"Littlestead",
Malcolm Close,
Ferring,
Worthing, West Sussex.
BN12 5NA

Re: Planning Application FG/27/18/PL - 58 Ferringham Lane, Ferring, West Sussex

TA 1078 / 17 rev.

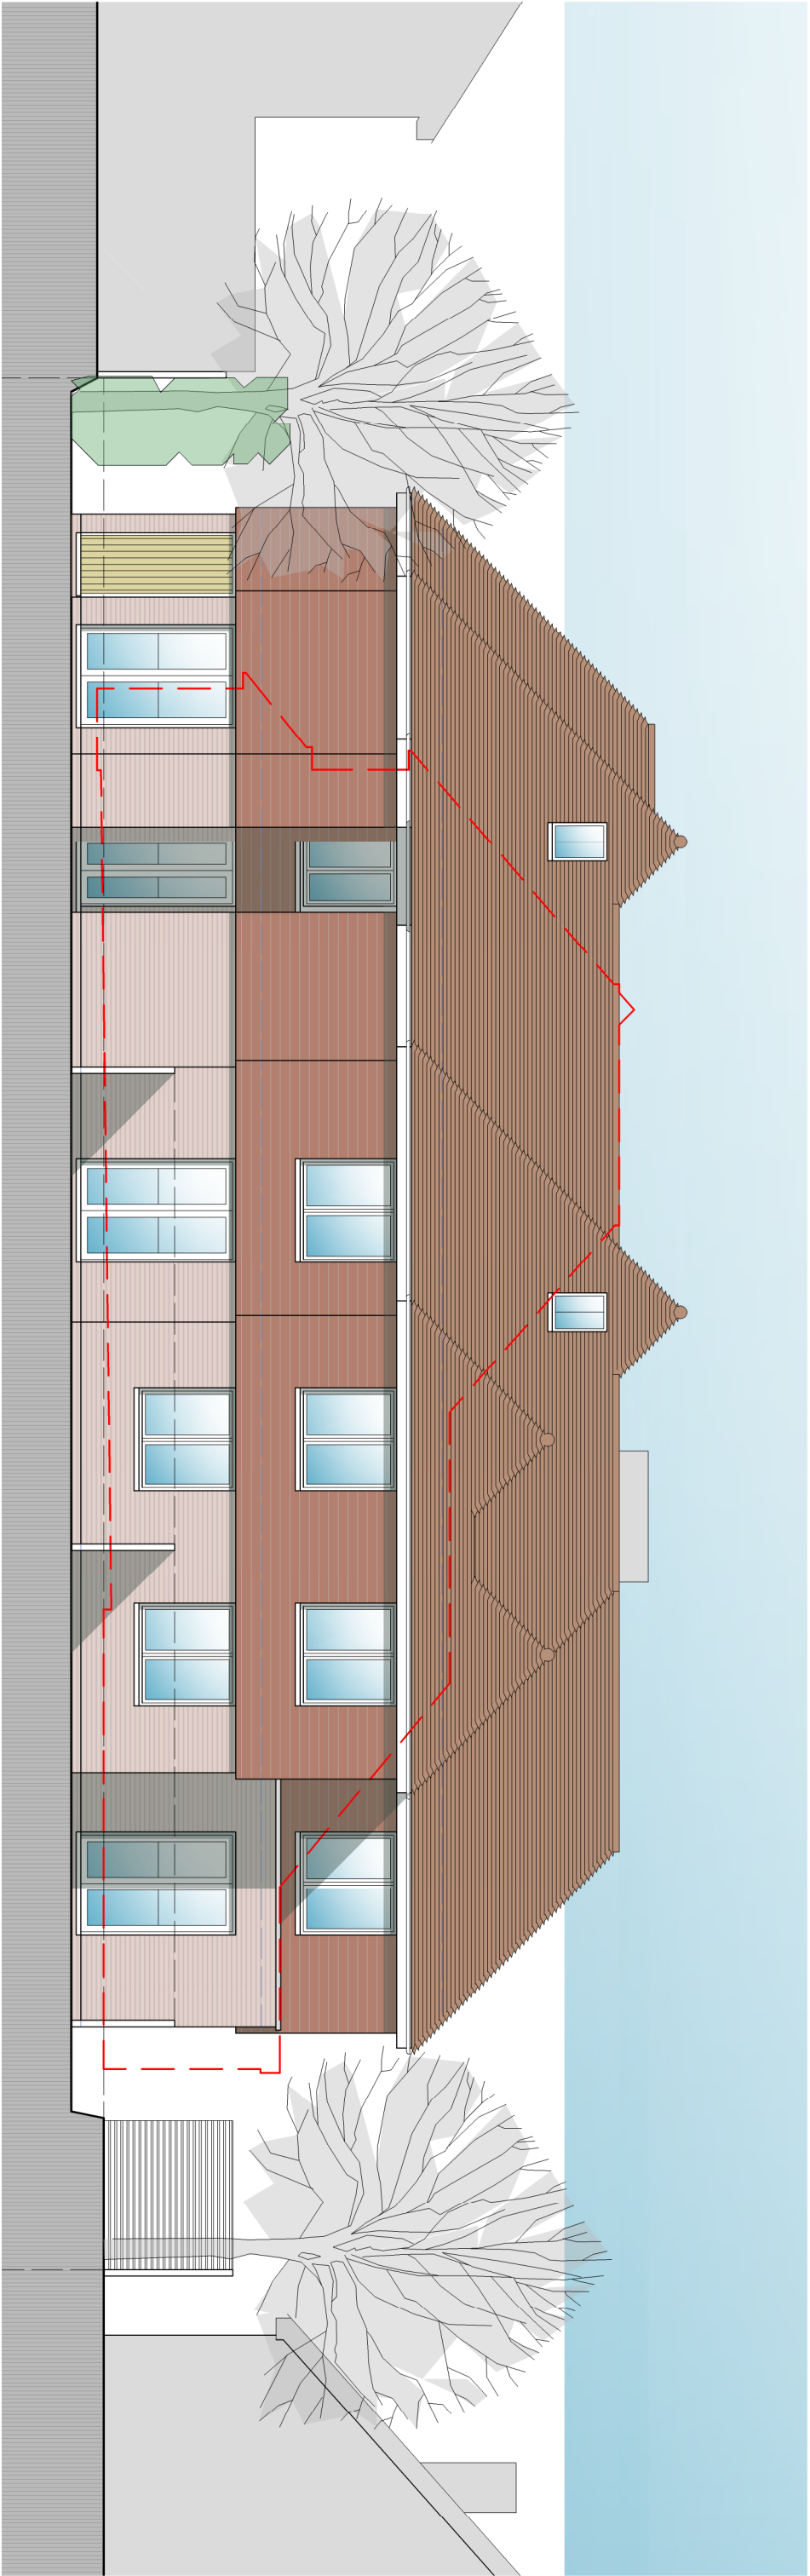
Also, the windows of the upper floors of the building will, naturally, overlook the rear gardens of the residences in Malcolm Close but it is not known how this will integrate with Arun District Local Plan policies GEN7 and DEV19 having regard to the recent planning conditions imposed in FG/5/16/HH No.2 Grange Park, adjoining. An aerial view of the location is attached.
